Our ref: NO/2025/116713/01-L01
Your ref: 3/2025/0107
Date: 07 April 2025

**RETENTION OF TWO HOLIDAY LODGES AND OFFICE BUILDING WITH
ASSOCIATED PARKING, INFRASTRUCTURE AND ALTERATIONS.
BOADICEA PARK, PRESTON ROAD, RIBCHESTER, PR3 3XL**

Proposed Lodge No. 5
 Boadicea Park, Preston Road,
 Ribchester, PR3 3XL

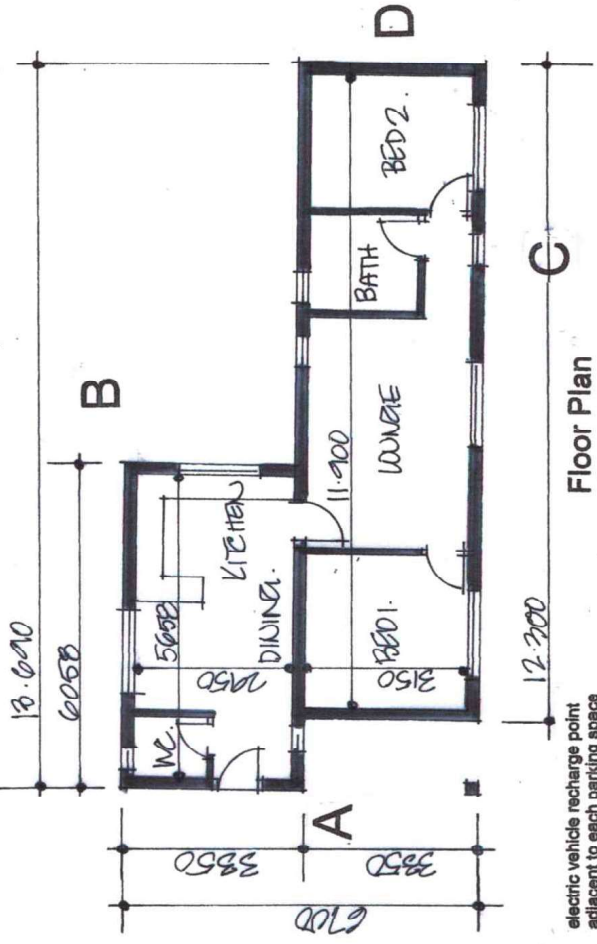
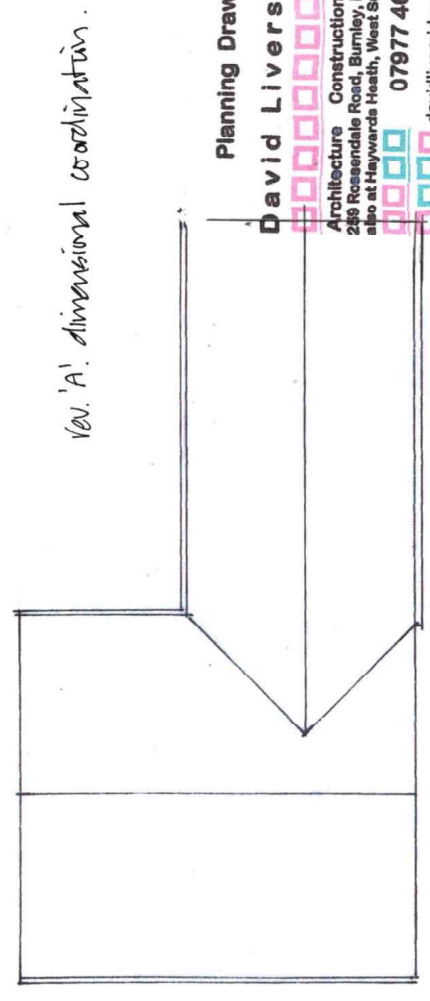
The current application proposes the relocation of lodges 5 and 6. Lodge 6 would be located within Flood Zone 2 while lodge 5 would be moved elsewhere within Flood Zone 3.

As the revised location of lodge 6 shows a betterment in terms of flood risk to that proposed in the extant permission, we have no objection to the proposed relocation of lodges 5 and 6. The applicant should understand that lodge 5 would potentially remain at a high risk of flooding and they may wish to further reconsider whether to locate this unit to part of the site at a lower risk.

Condition No development shall take place until a flood management strategy for Lodges 5 and 6 has been submitted to, and approved in writing, by the local planning authority. The strategy should include.

- Plans to anchor the lodges to the ground.
- Measures to mitigate flood damage within the lodges during a flood event.
- A flood evacuation plan which includes signing up for flood warnings.

'Existing' Site Plan and Block Plan Layout

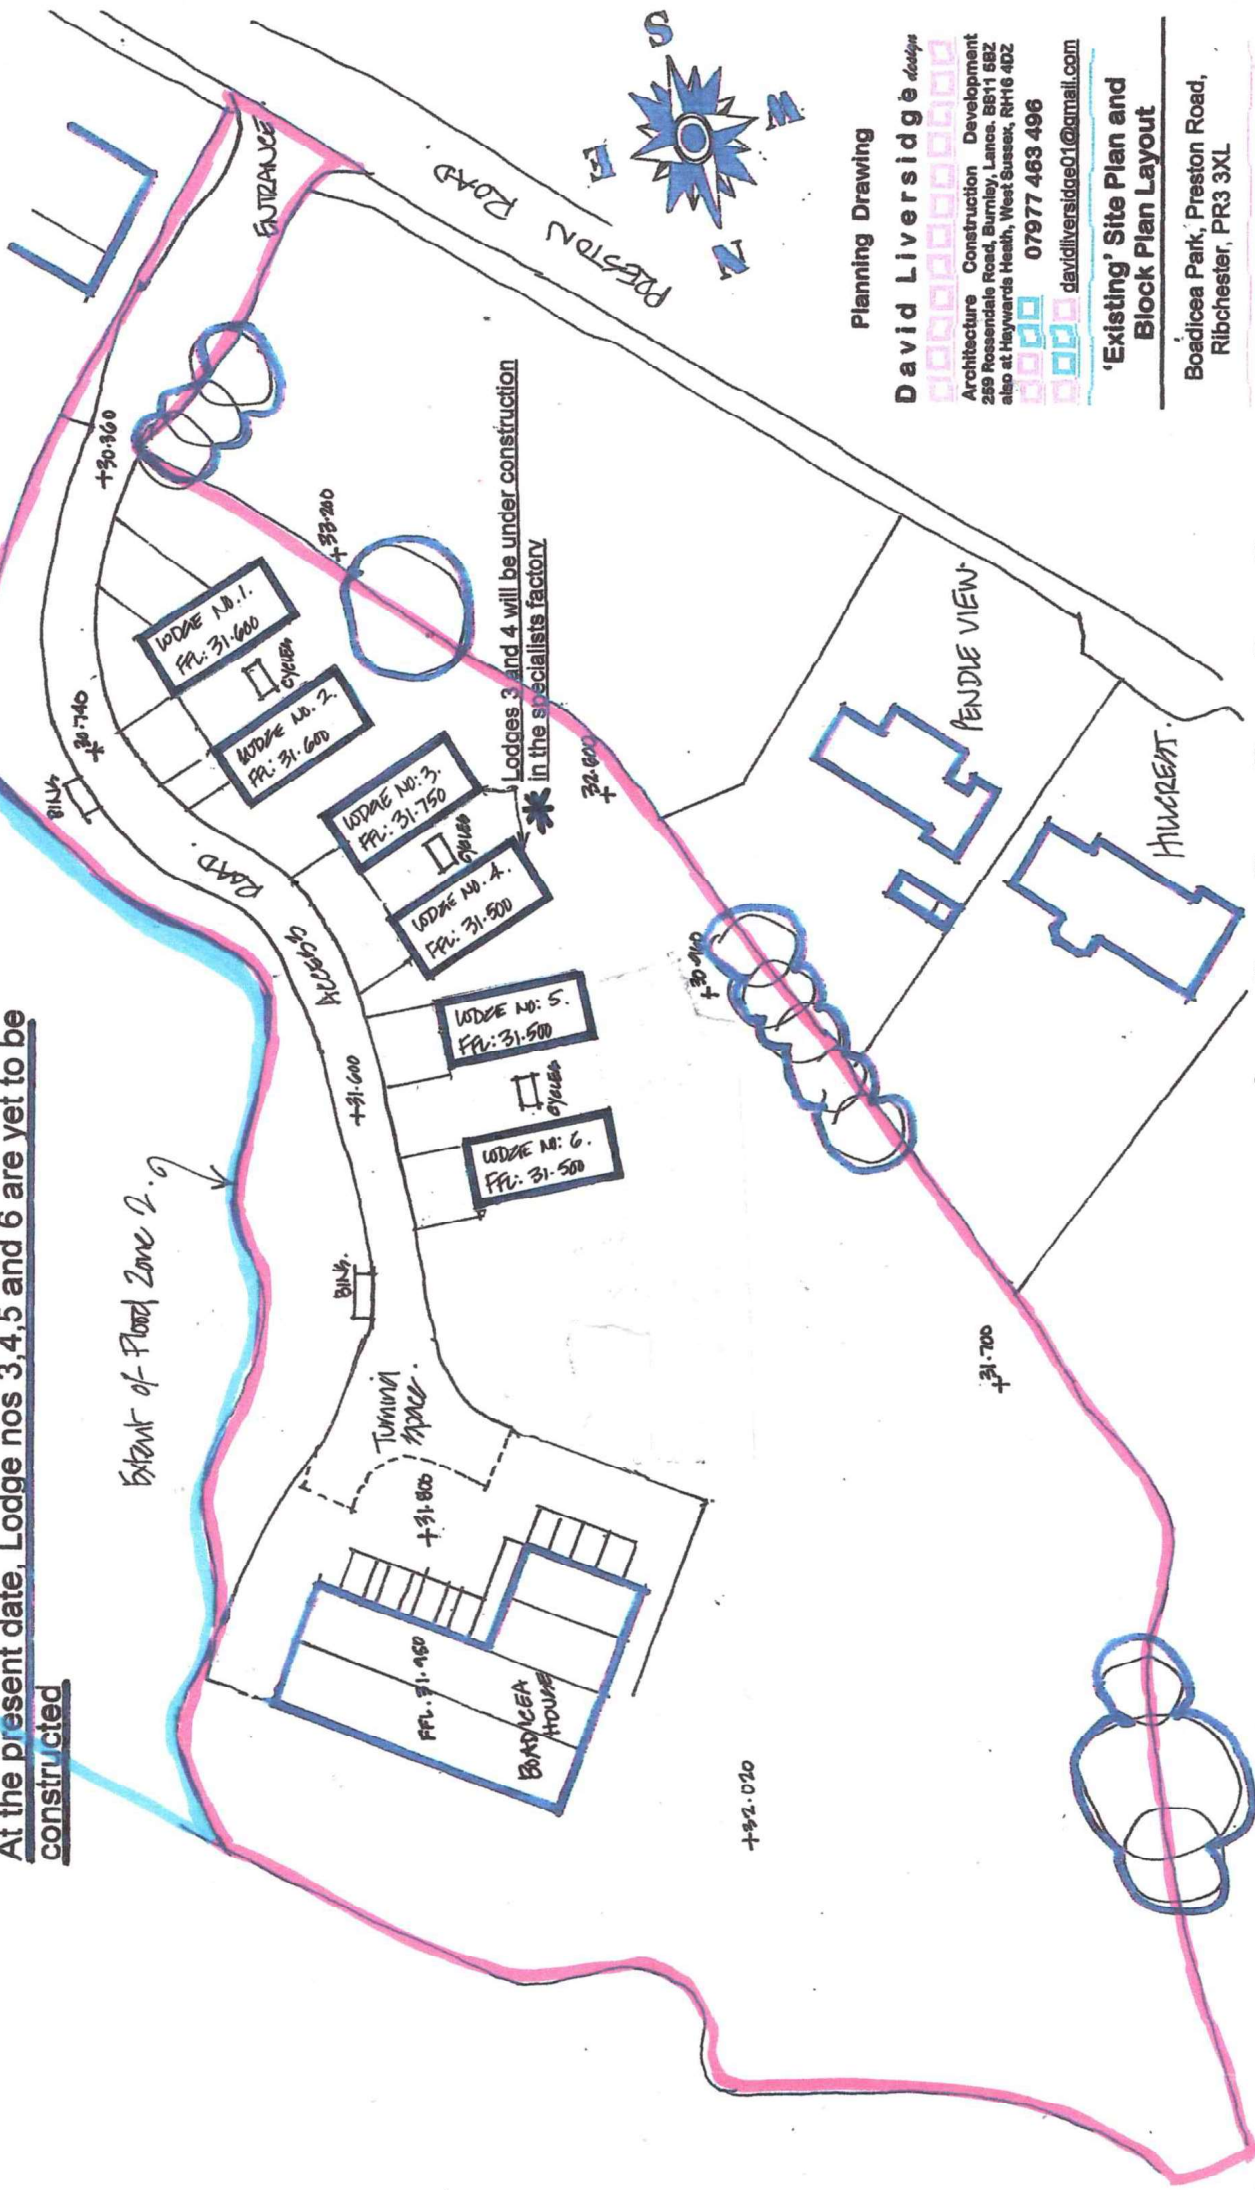
We previously responded to an application for this site, your reference 3/2021/0595, our reference NO/2021/113649/01-L01, dated 08 July 2021, and had no objection to the proposal. Subsequent to the site obtaining planning approval in September 2021, the Environment Agency's Flood Map for Planning (FMfP) has been revised. The FMfP was updated 25 March 2025 and shows the two lodges that are proposed for relocation are now located in Flood Zone 3 on the approved plans, Flood Zone 3 being land at high risk of flooding.

We have specifically linked this condition to the current proposal, but we would advise the applicant to consider the management of flood risk to any other units approved under the extant permission which are now at risk of flooding, i.e. units 3 and 4.
